OFFICIAL NOTICE OF DECISION

CITY OF ALBUQUERQUE
PLANNING DEPARTMENT
DEVELOPMENT REVIEW BOARD

13. Project # 1002520

RIO GRANDE ENGINEERING agent(s) for JENNIFER SOULE request(s) the above action(s) for all or a portion of Lot(s) 15 & 16, Tract(s) 2, Block(s) 4, **NORTH ALBUQUERQUE ACRES, UNIT 3**, zoned R-D residential and related uses zone, developing area, located on ALAMEDA BLVD NE, between WYOMING BLVD NE and LOUISIANA BLVD NE containing approximately 2 acre(s). [REF: 04DRB00705] (C-19)

**LEGAL DESCRIPTION:**  
 LOTS 15 AND 16, NORTH ALBUQUERQUE AVENUE, BLOCK 1

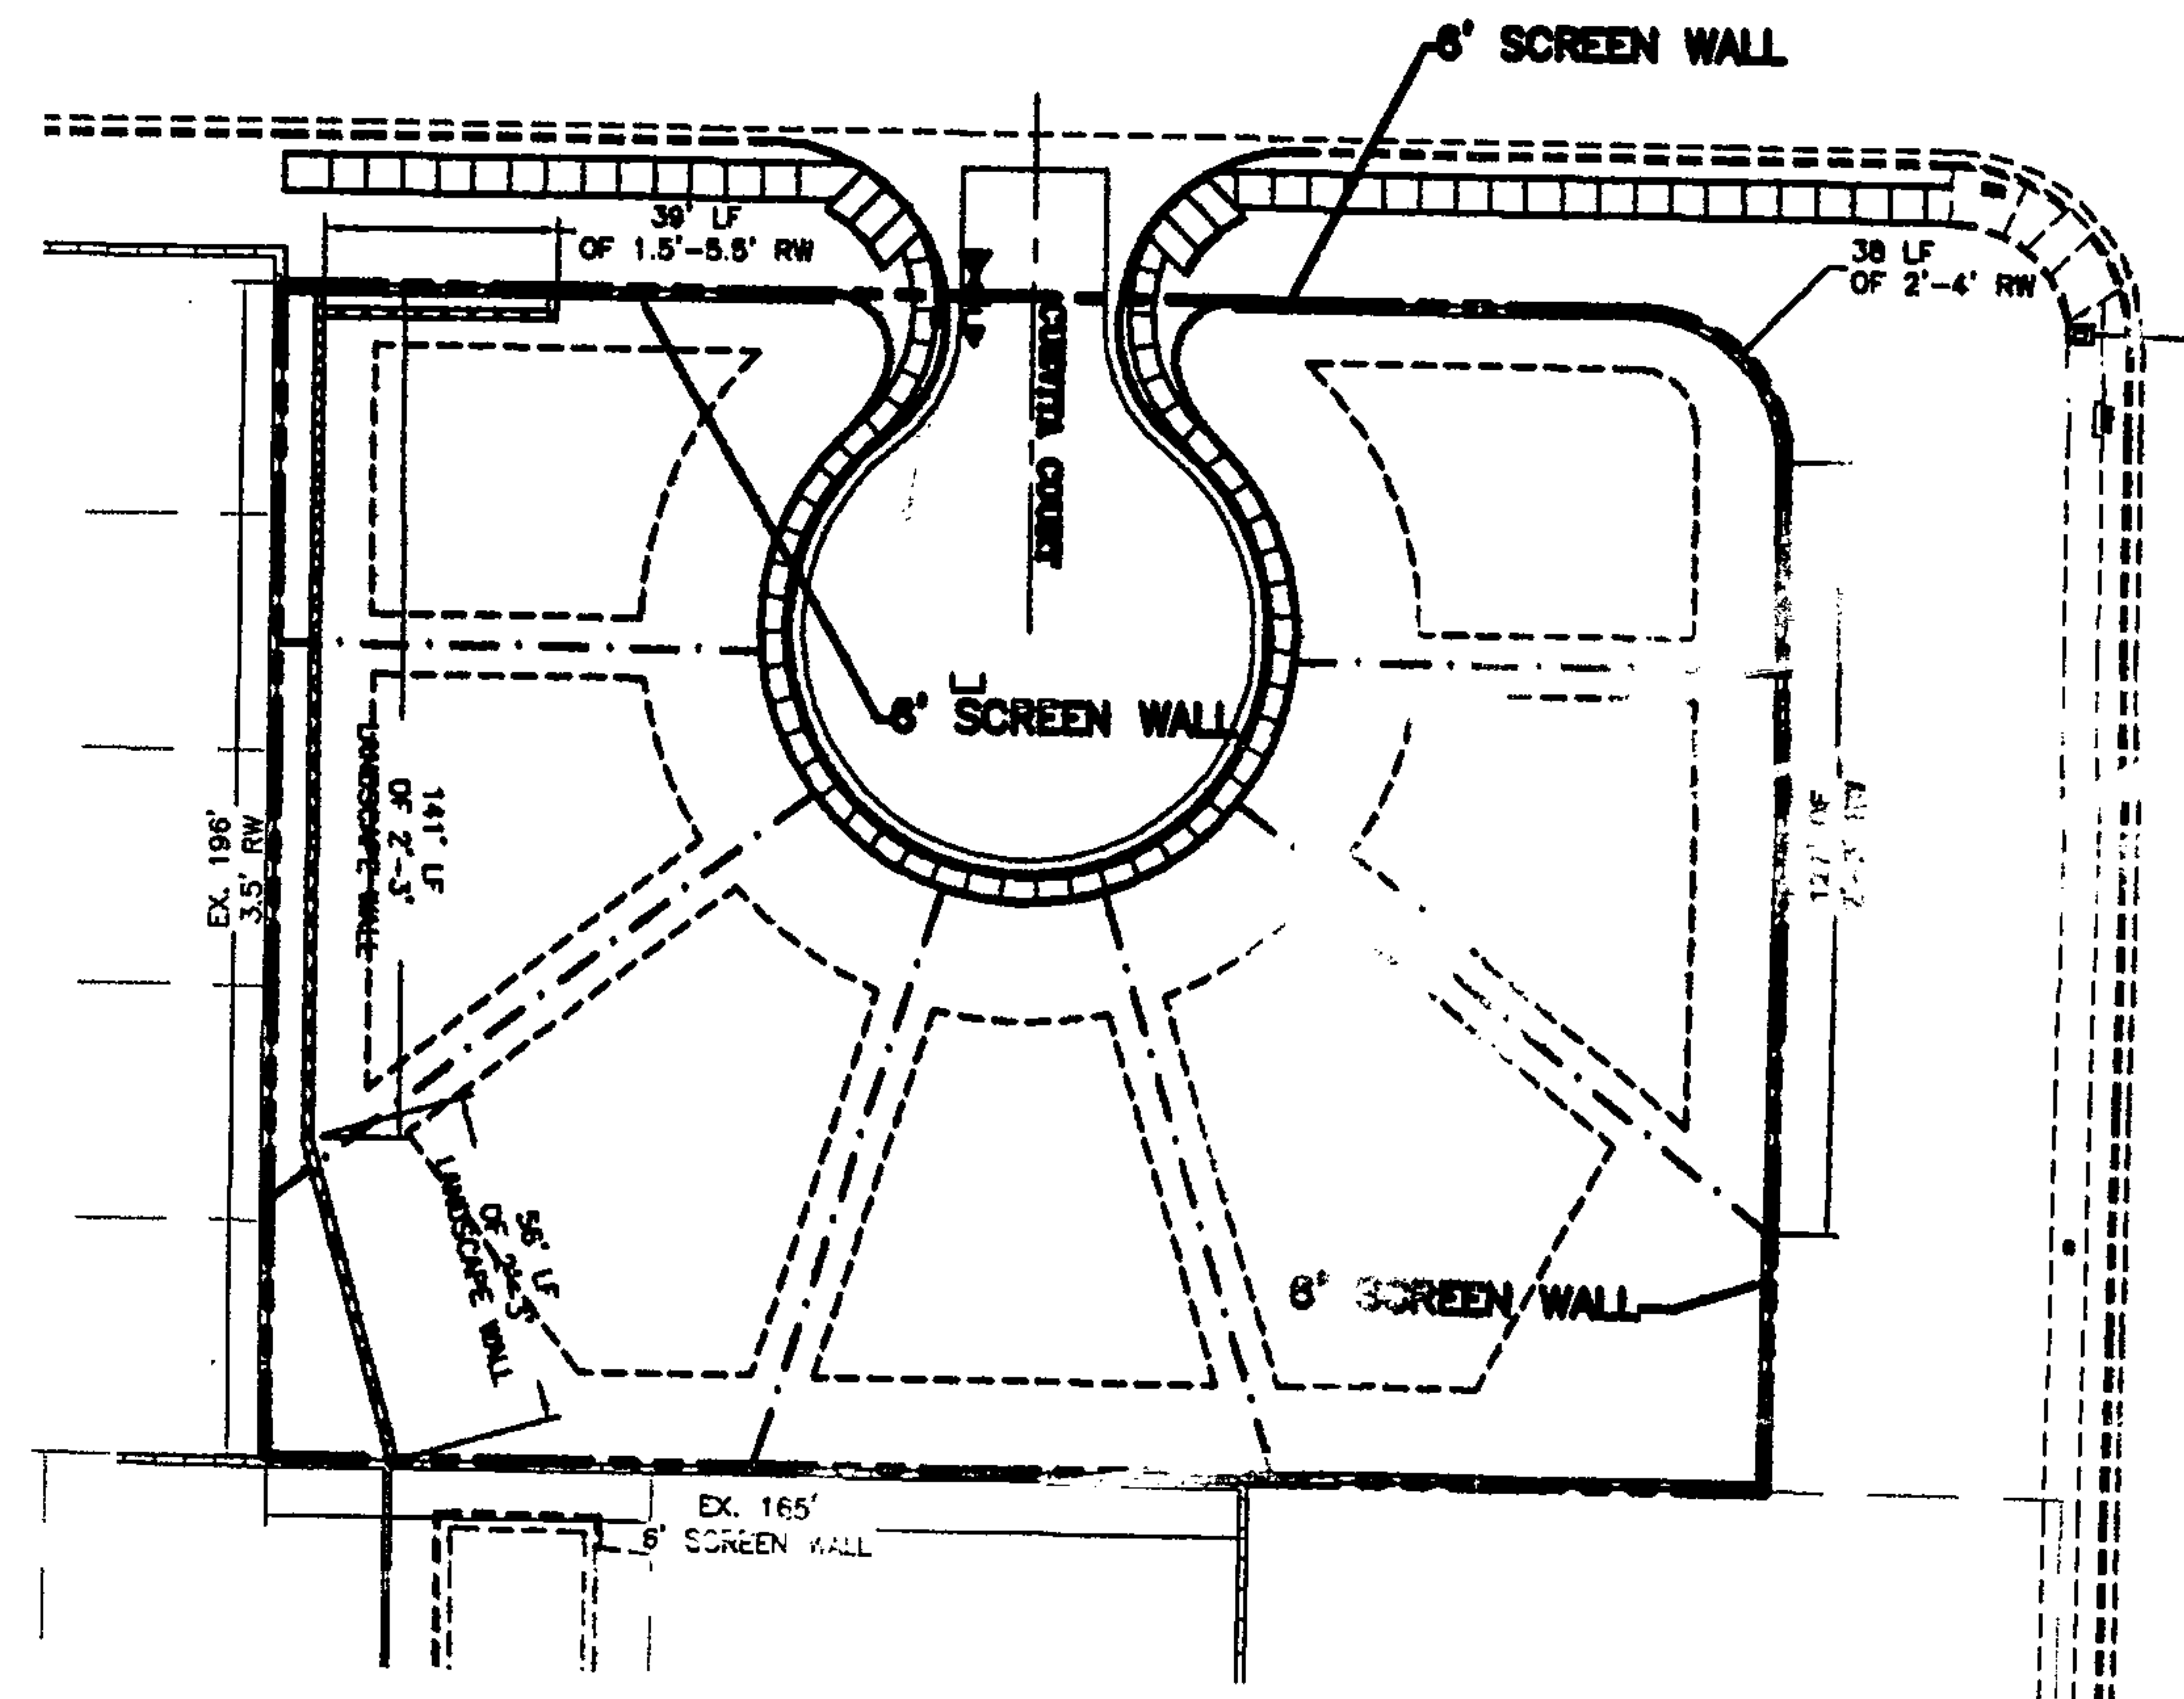
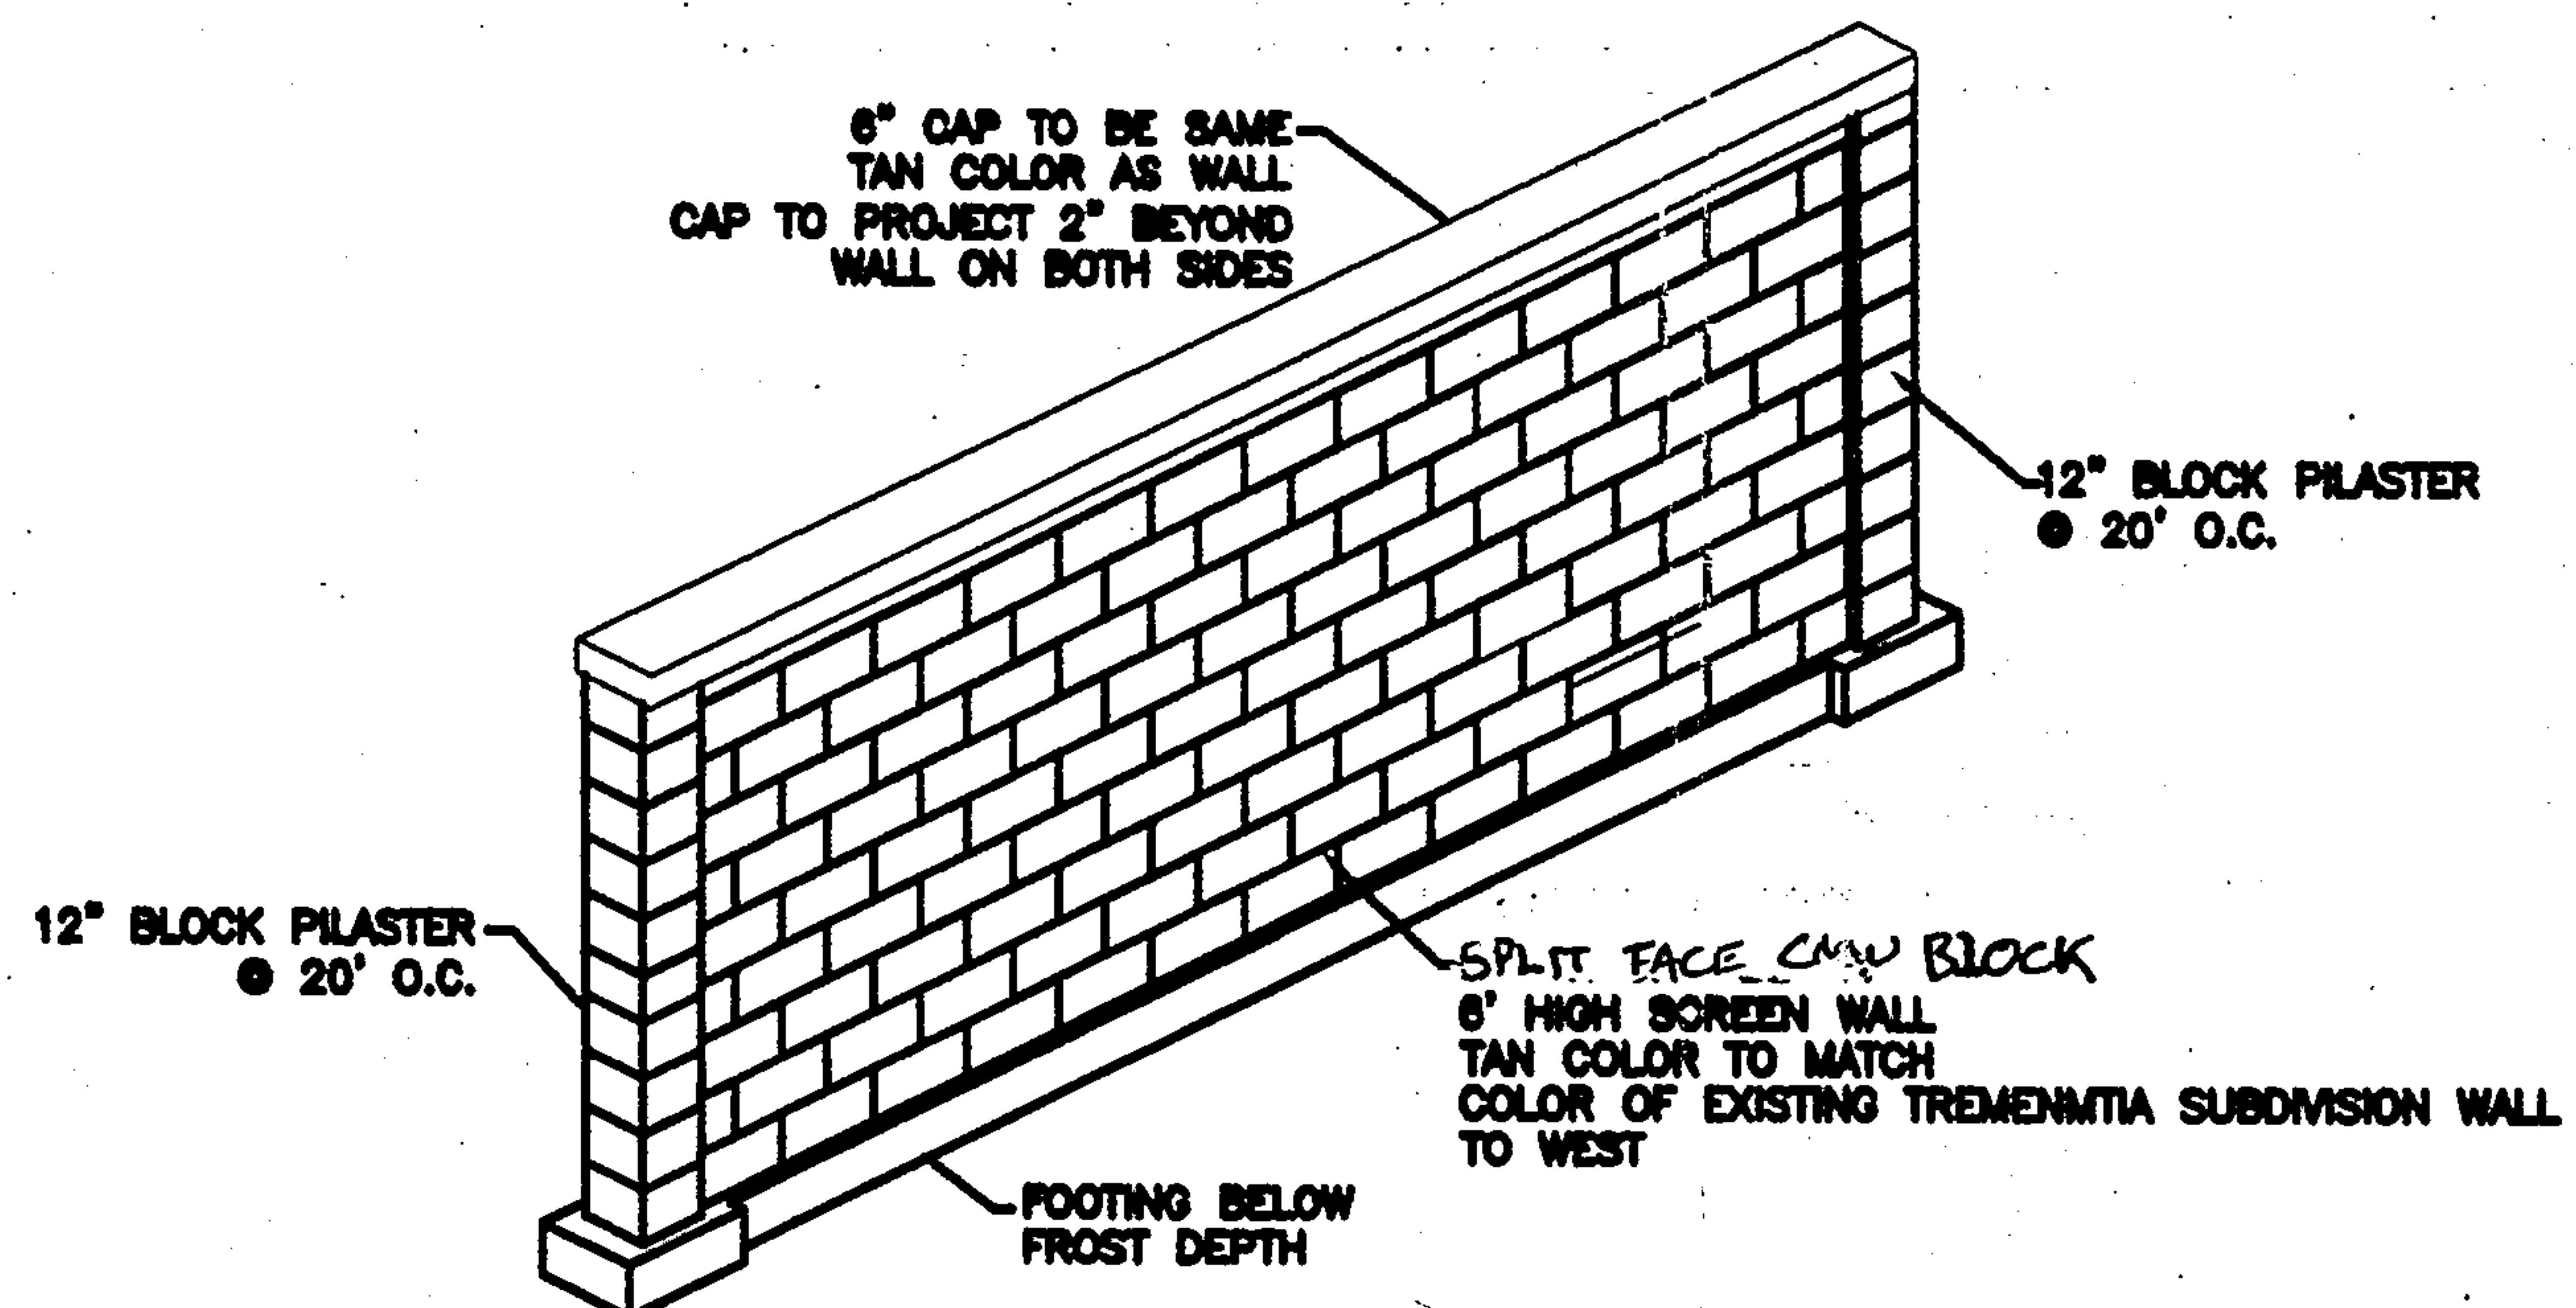
Wall design submittal shall be revised to meet Zone Code requirements.
